Our ref: HA/2017/119978/01-L01
Your ref: F/32/17/PL
Date: 19 December 2017

EXISTING ANCILLARY BUILDING TO BE USED AS A TOURIST UNIT 1ST APRIL TO THE 30TH SEPTEMBER ONLY.

RIFE COTTAGE 1 STATION ROAD FORD BN18 0BJ

Environment Agency position

PROPOSED WORKS TO ALLOW EXISTING ANCILLARY BUILDING TO BE USED AS A TOURIST UNIT RIFE COTTAGE, 1 STATION ROAD, FORD.

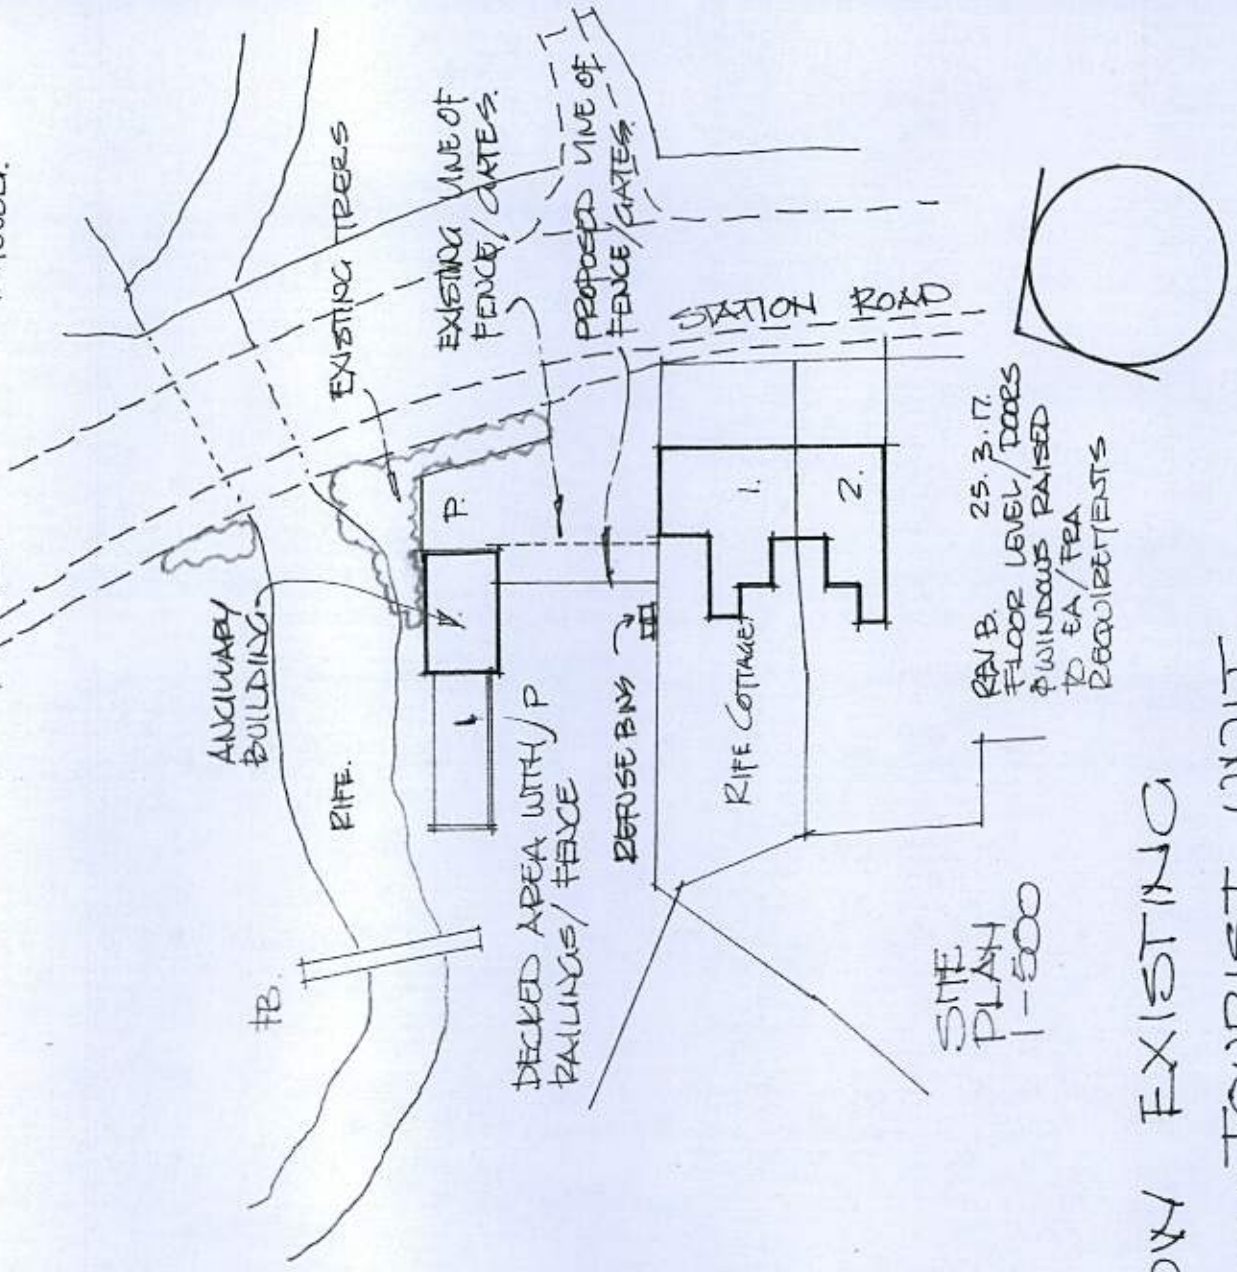
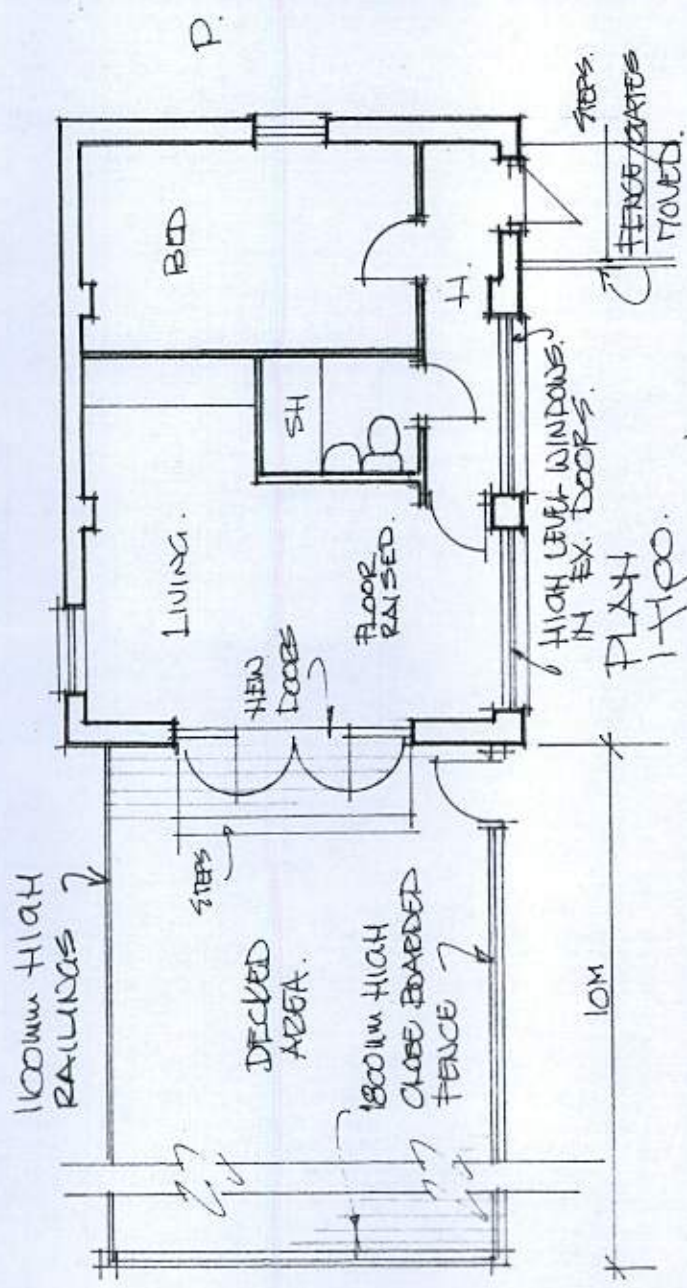
- **Finished floor levels are set no lower than 3.12 metres above Ordnance Datum (AOD).**
- **Occupancy between 1 April and 30 September only.**
-
